East Anglia ONE North and East Anglia TWO Offshore Windfarms

Applicants' Comments Suffolk County Council's Deadline 11 Submissions

Document Reference: ExA.AS-13.D12.V1

Date: 28th June 2021

## Appendix 5: Plan and Cross Sections of Indicative SuDS Basins

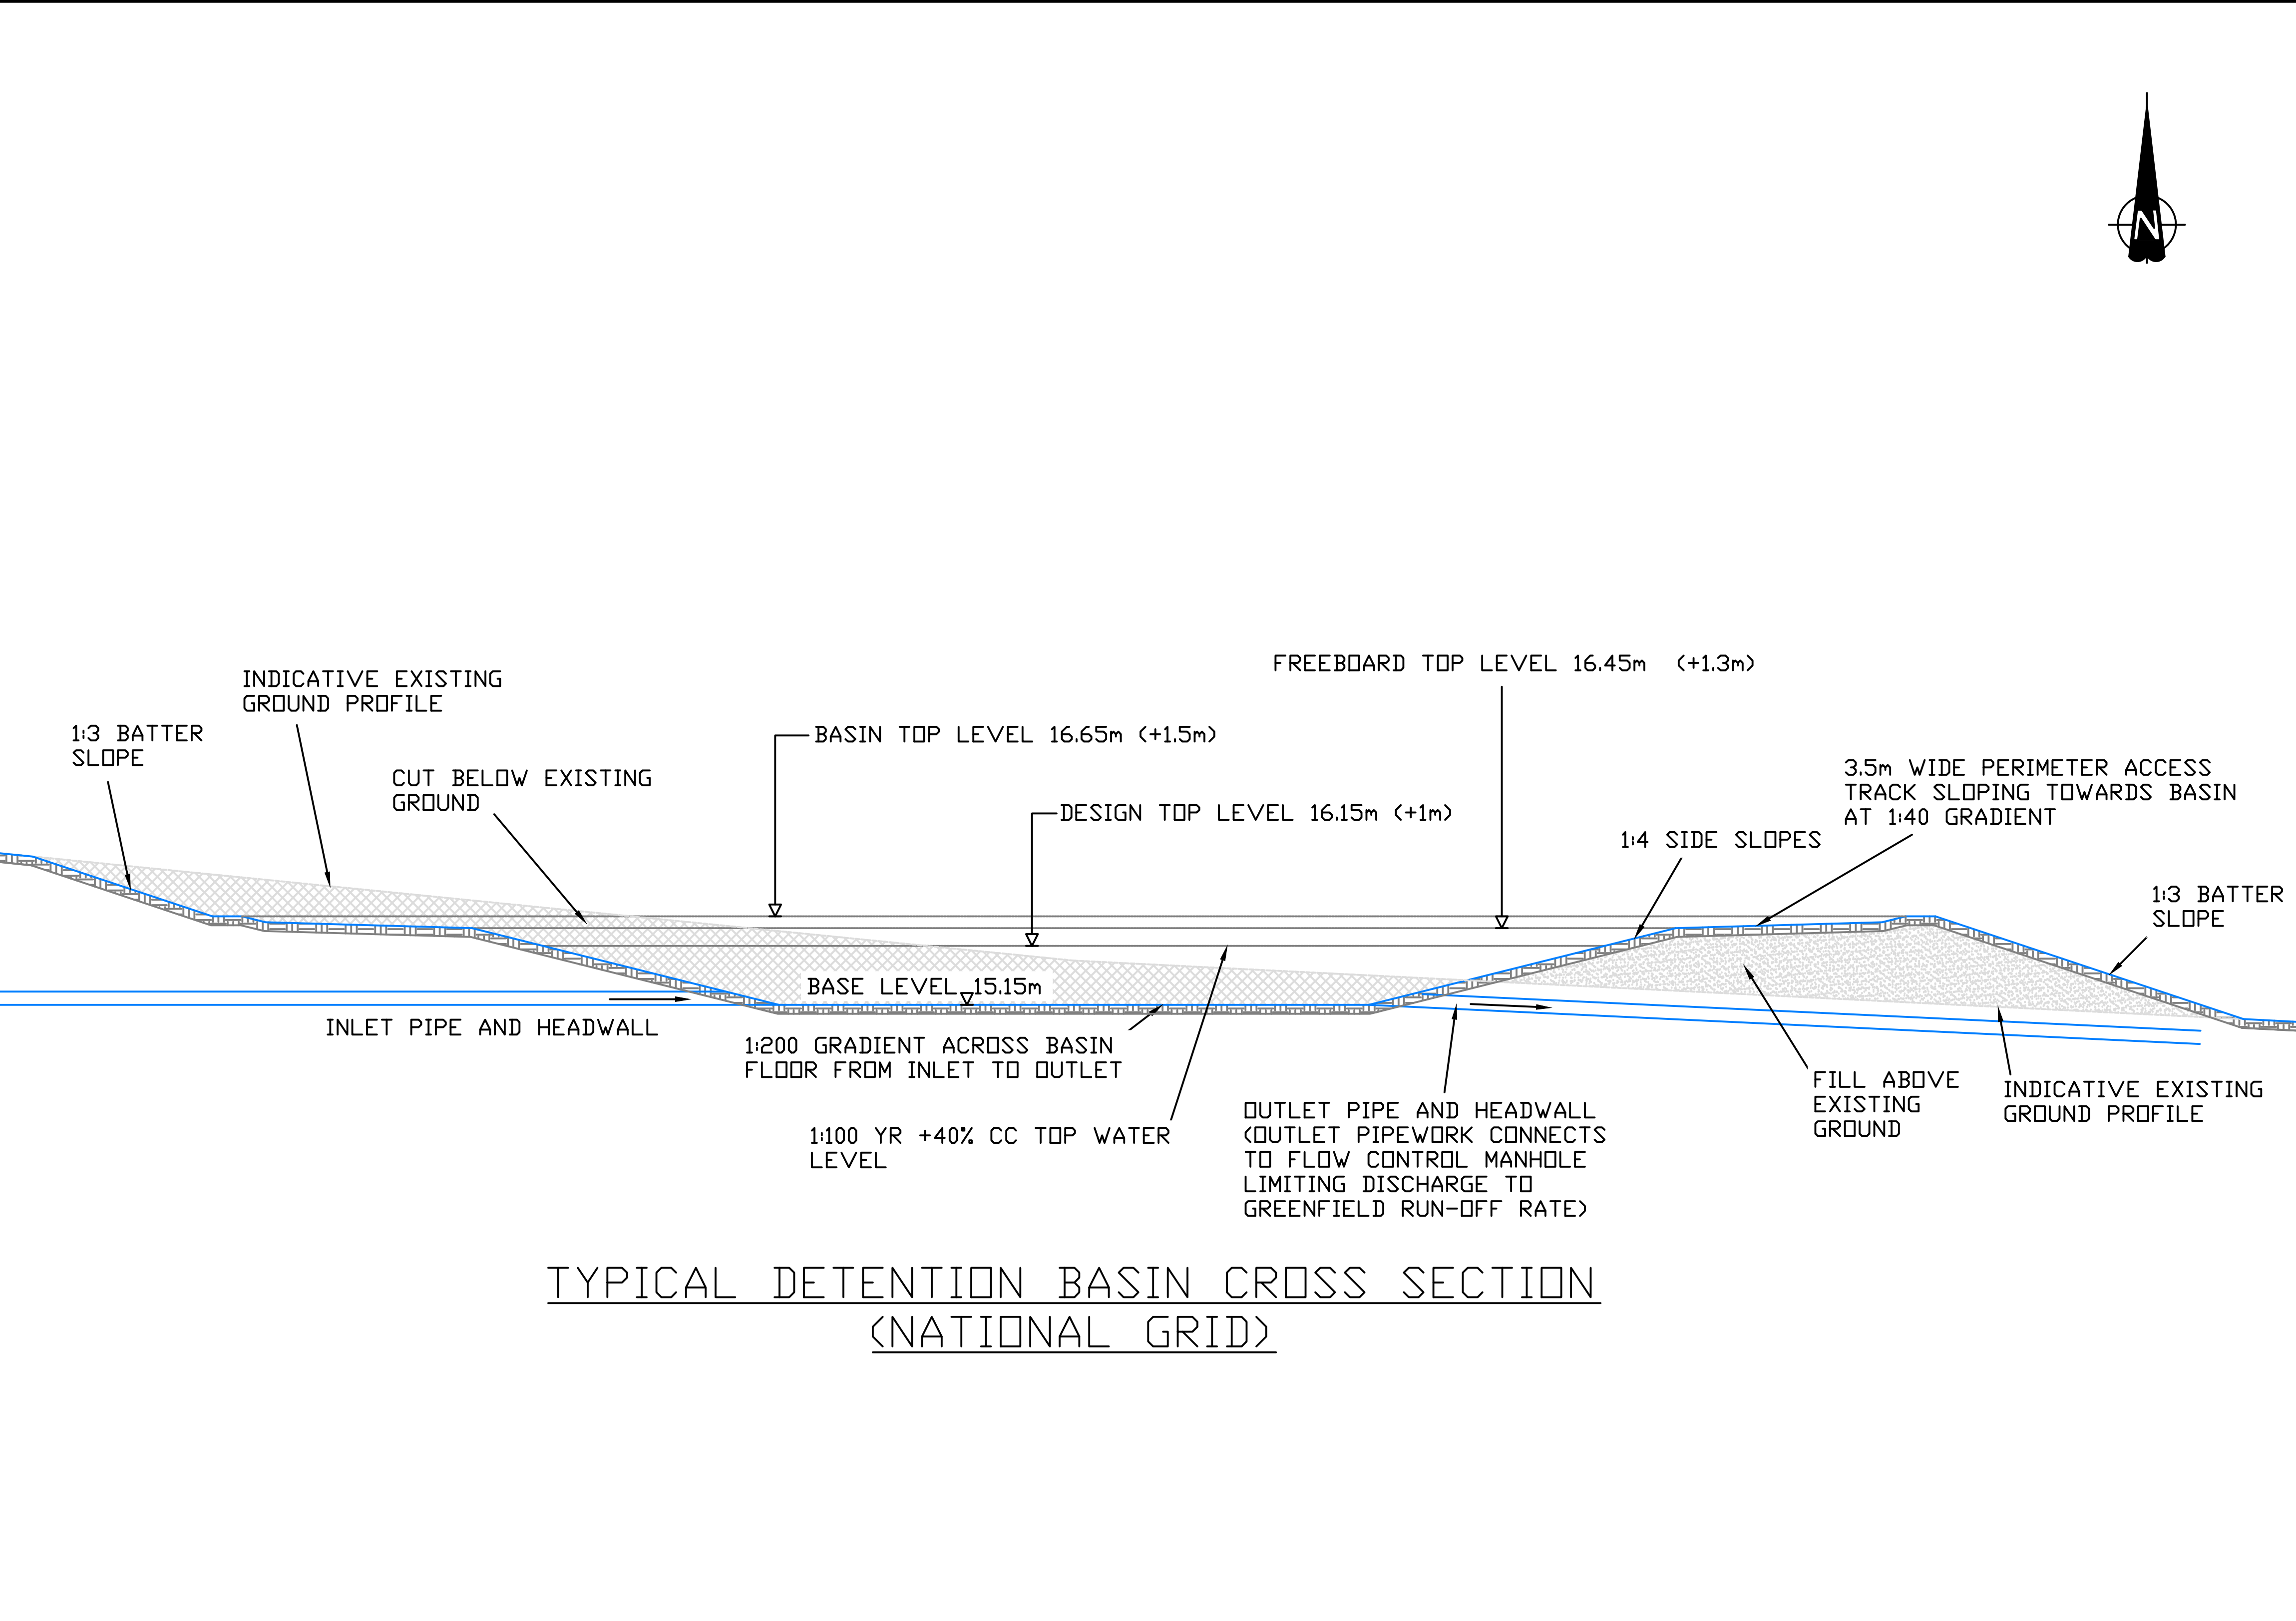
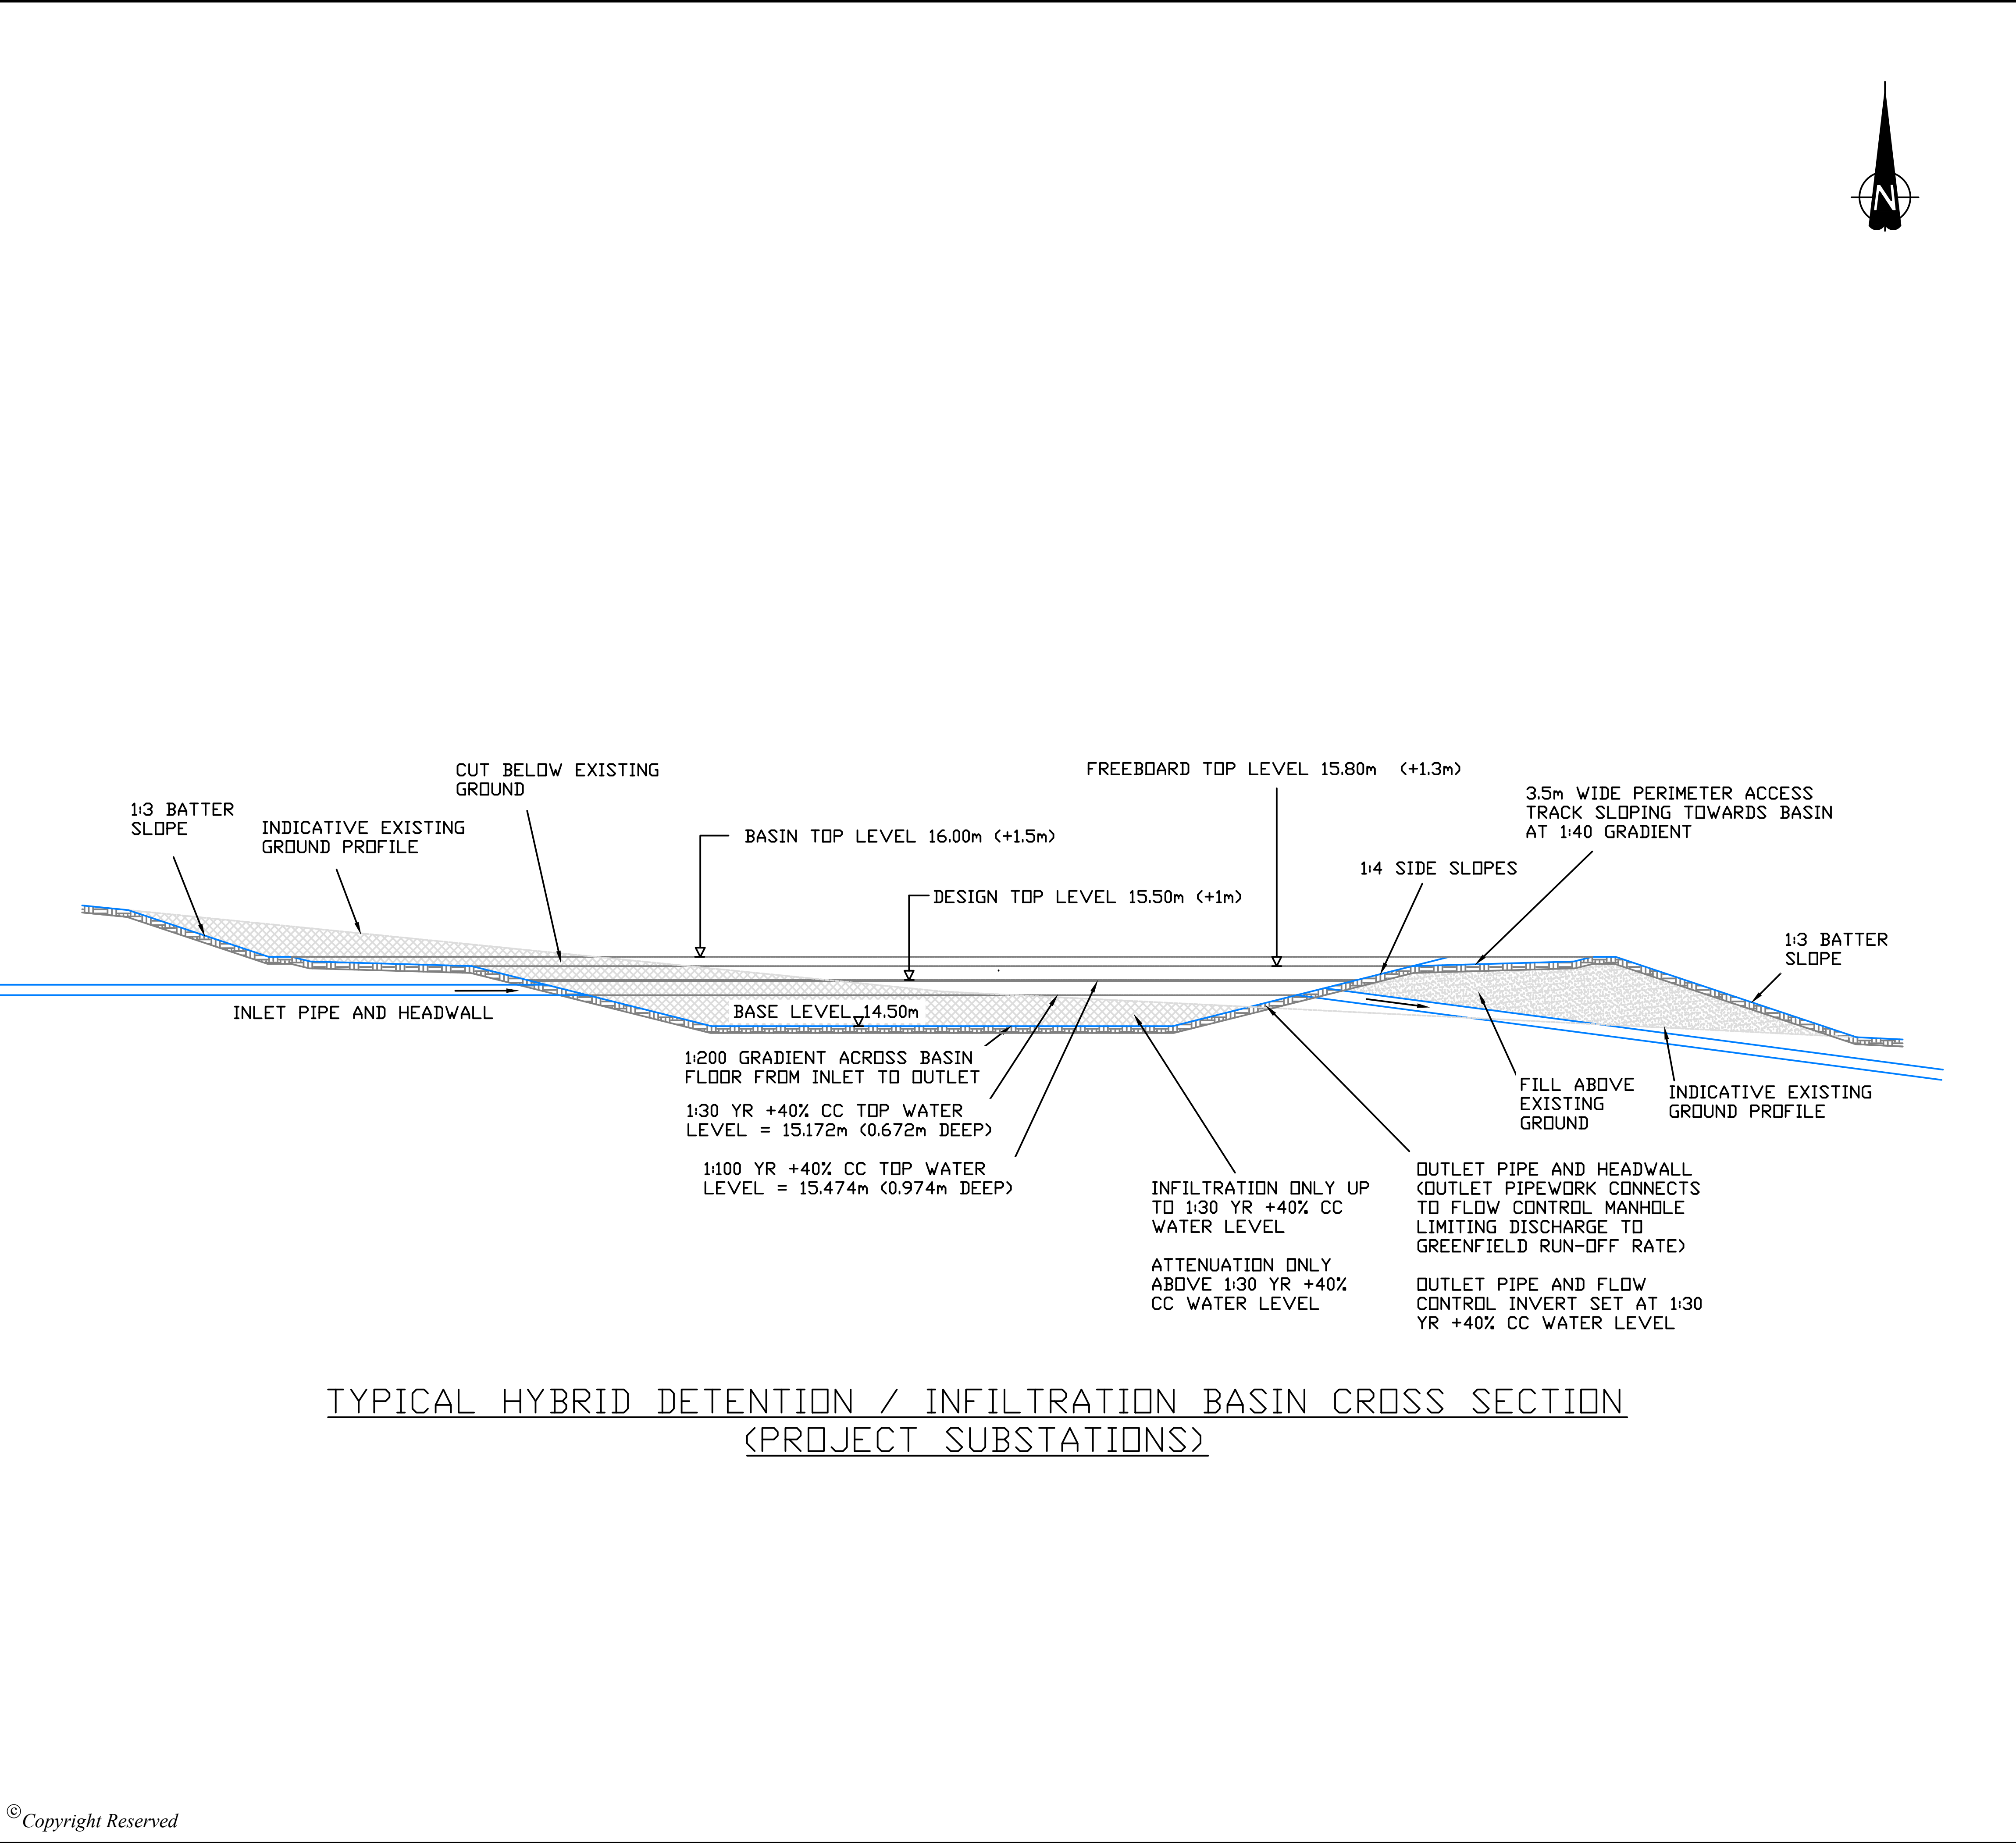
ID	ExA's Question	SCC Comment	Applicants' Comments
		<p>risk is not there, which based on evidential internal flooding, it clearly is.</p> <p>The indicative design (side slope gradients, maximum water depths, total basin depths etc.) is generally acceptable, with exception to the depths used for the hybrid design option, as detailed in 'c' below.</p>	
5		<p>C.)</p> <p><u>Infiltration/hybrid storage volumes in D8</u></p> <p>Infiltration only storage required = 37,081m³ Infiltration only storage provided = 37,388m³ Hybrid storage required = 36,173m³ Hybrid storage provided = 36,913m³</p> <p>As shown in Appendix 6 of the Deadline 8 OODMP (REP8-064): Total basin depth = 2.0m. This exceeds the CIRIA SuDS Manual guidance of a maximum total depth of 1.5m for basins. It is unclear why 2.0m depth is required if water levels are not exceeding 1m? Water depths have the potential to exceed 1m, when 1:100+40% is combined with 1:10+40% after 24 hours, however, no assessment of this has been undertaken.</p> <p>Maximum water levels should be shown on future sections. This should be either after 1:100+40%, or after a further 1:10+40% storm is added after 24 hours, whichever results in the greater water level.</p>	<p>The updated version of the OODMP (AS-125) presents revised modelling and designs for the proposed basins.</p> <p>Maximum water levels are included on the cross section plans within the updated OODMP.</p>

ID	ExA's Question	SCC Comment	Applicants' Comments
24	ID 21	<p>The 'base level' and 'basin top level' for both the NG & EA1N/EA2 substations result in a total depth of 2.0m. If this is 'incorrect and misleading', as per the Applicants statement, is the plan wrong? During ISH16, the Applicant appeared to acknowledge the hybrid basins exceeded 1.5m total depth.</p> <p>If the plan is correct, then the total depth of the basin is greater than that recommended in the CIRIA SuDS Manual.</p> <p>What is the plan area of the basins if designed in compliance with CIRIA SuDS Manual criteria?</p>	<p>Revised designs for the National Grid infrastructure basin and onshore substations basin are presented in the updated OODMP (AS-125).</p> <p>Appendix 5 of the OODMP provides cross sections of each of the basins, indicating that the design top level are 1.0m and basin top level are 1.5m.</p>
25	ID 23 & 33	<p>Maintenance of the Friston Main River is the responsibility of the Environment Agency.</p> <p>SCC acknowledge and welcomes the Applicants intentions to maintain the Friston Main River, to ensure that siltation does not prevent the effective outfall of any surface water connection to the Main River, from the Projects, remains operational. SCC request that maintenance proposals, including inspection, is included in the maintenance proposals contained within the OODMP. SCC appreciate the exact details of this will not be agreed until ODMP.</p> <p>SCC understand that revised details for a connection to Friston Main River will be submitted by the Applicant at Deadline 11. Therefore, we will reserve further comment on this matter at this time, pending further submission of details by the Applicant.</p>	<p>Further details of proposed maintenance will be included in the final Operational Drainage Management Plan that will be developed post-consent.</p> <p>See response at ID6 which confirms SCC's acceptance of the outfall concept design.</p>
